17 April 2019

**Arrangements for Handling Heritage Applications Direction 2015
& T&CP (Development Management Procedure) (England) Order 2015
& Planning (Listed Buildings & Conservation Areas) Regulations 1990**

**LAND TO THE NORTH OF CASTLE STREET AND SOUTH EAST OF
WATERHOUSE LANE INCLUDING CASTLE BUILDINGS AND THE EARL DE
GREY PUBLIC HOUSE, KINGSTON UPON HULL, HU1 2DA
Application Nos 19/00334/LBC & 19/00333/FULL**

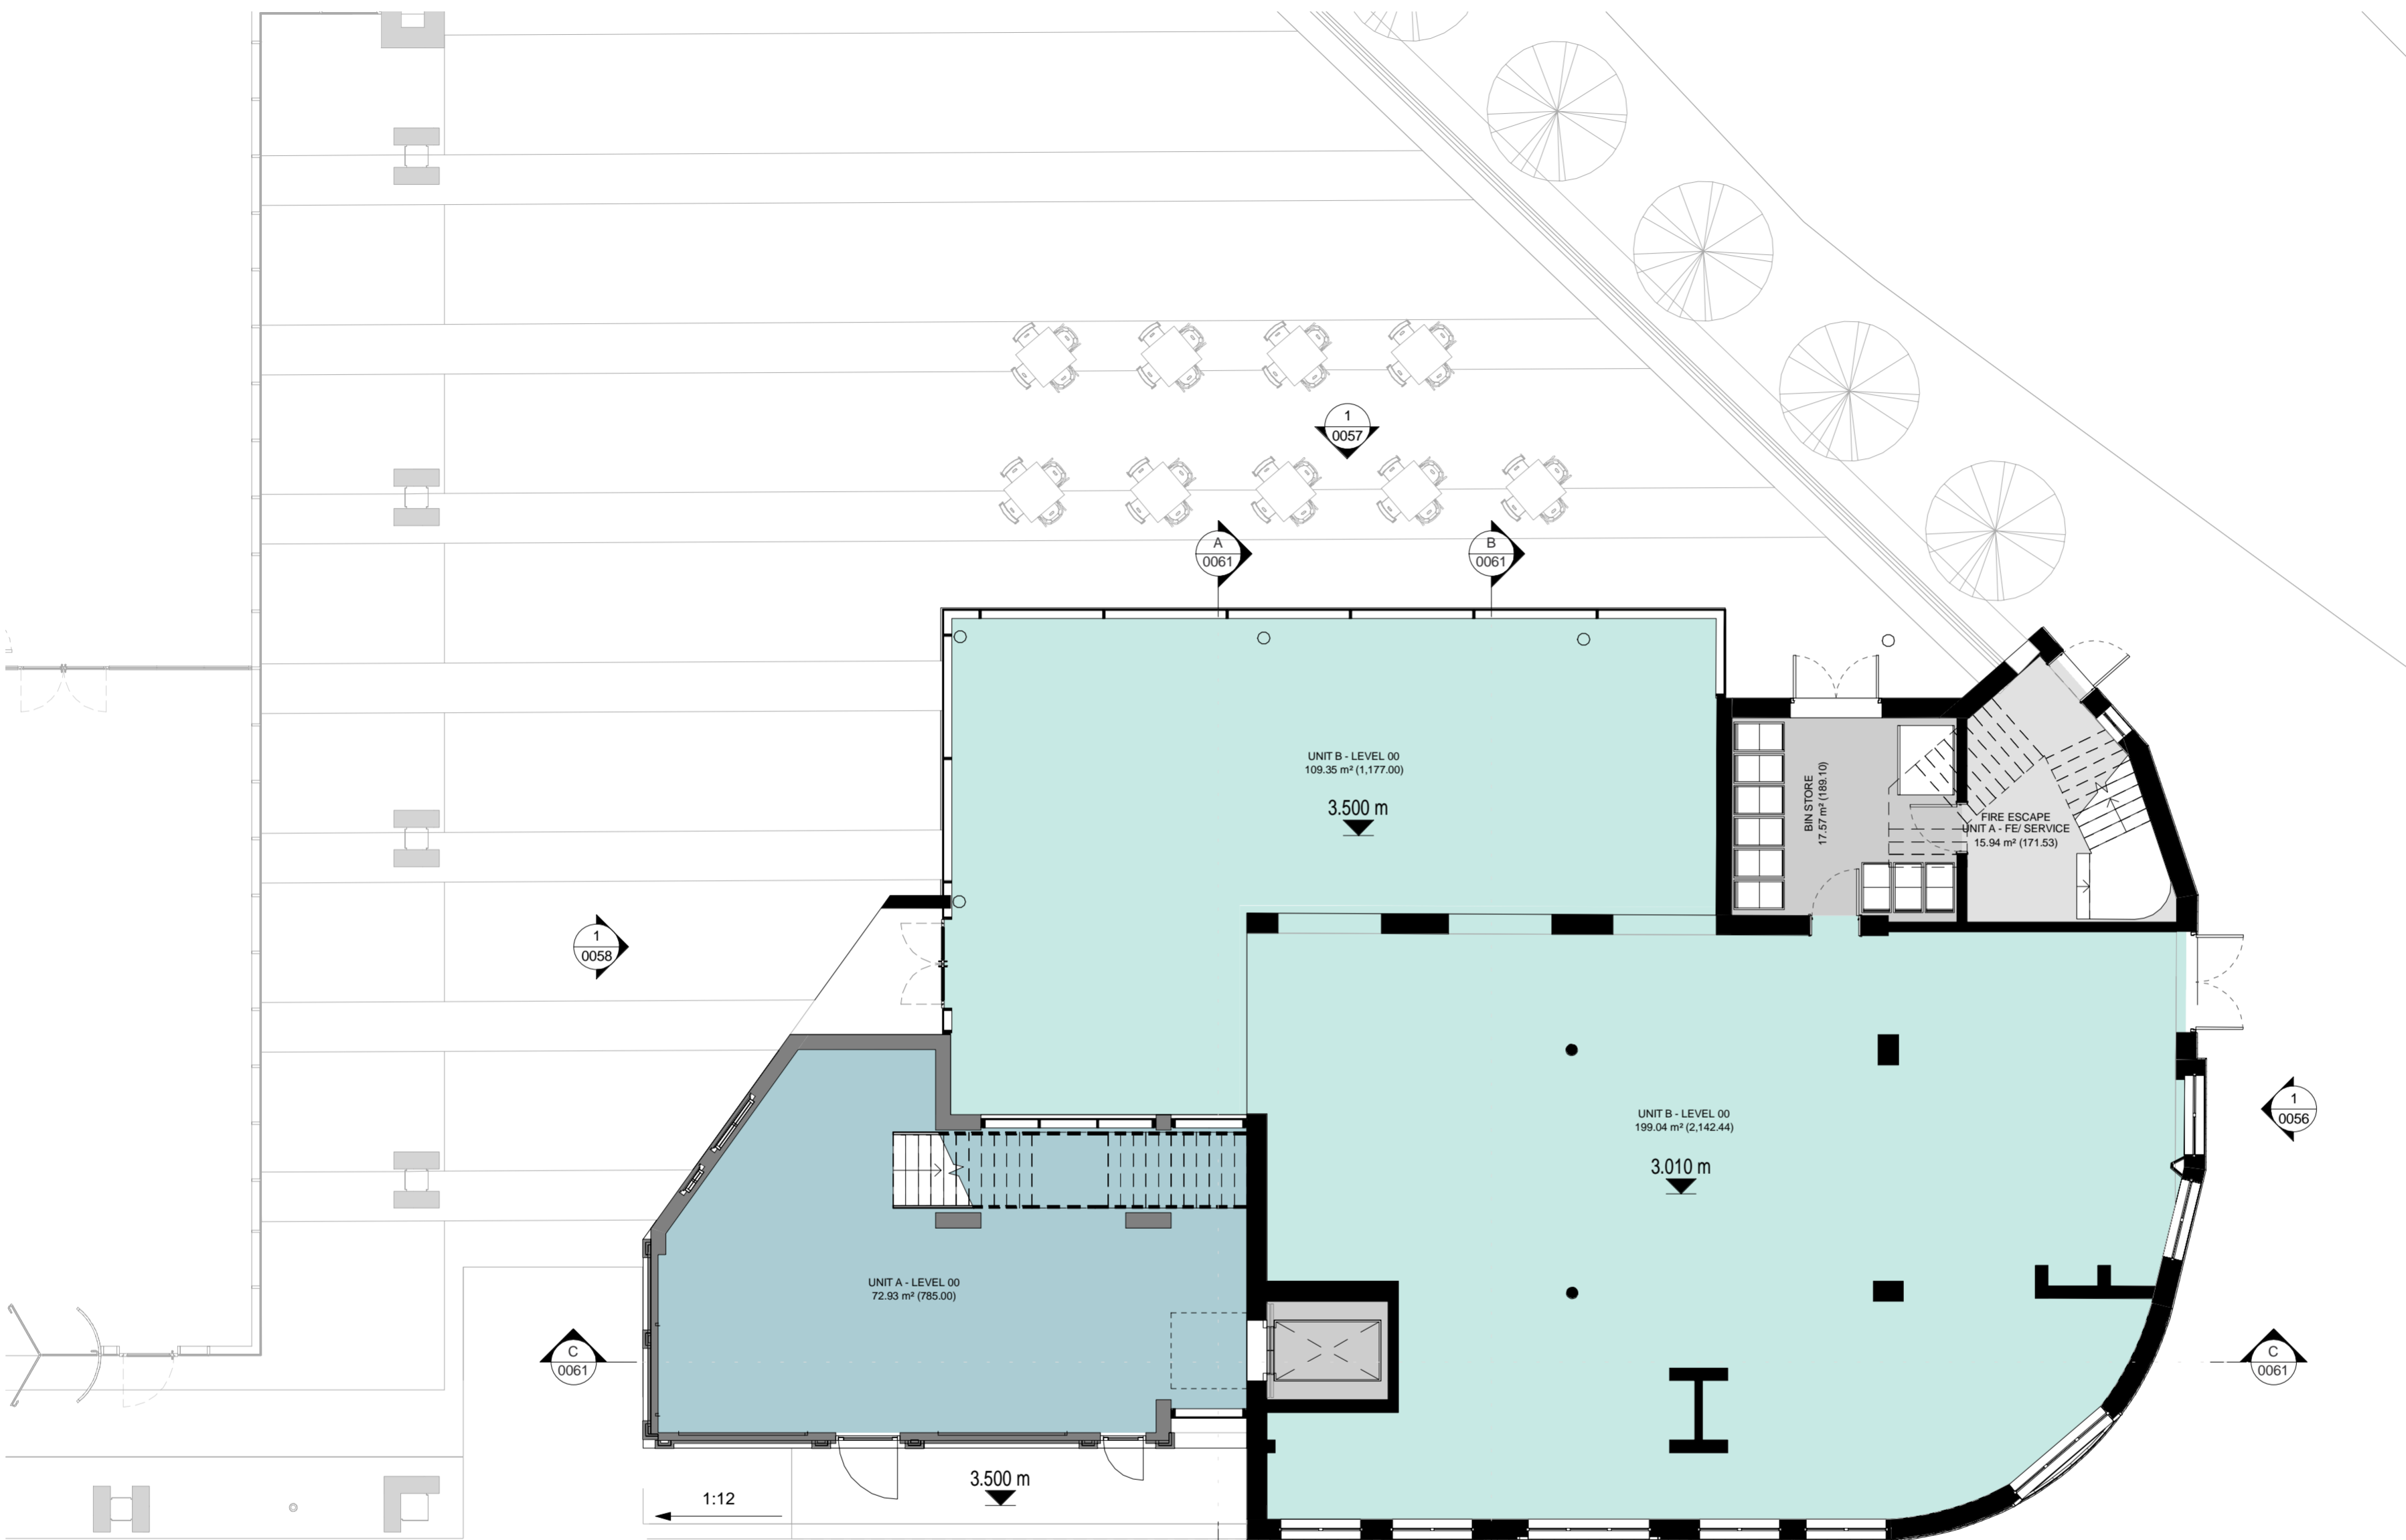
- The proposed internal layout of the repositioned Earl de Grey as proposed does not respond positively to its significance. A major portion of the interior is proposed to be used for a new staircase which compromises the amount of useable space. We advise that a new staircase should be smaller, ideally a bespoke carpentry piece but if it needs to be larger we question whether the staircase could be reconfigured and relocated to the modern extension (glazed link building) thus removing this element from the listed part of the building.
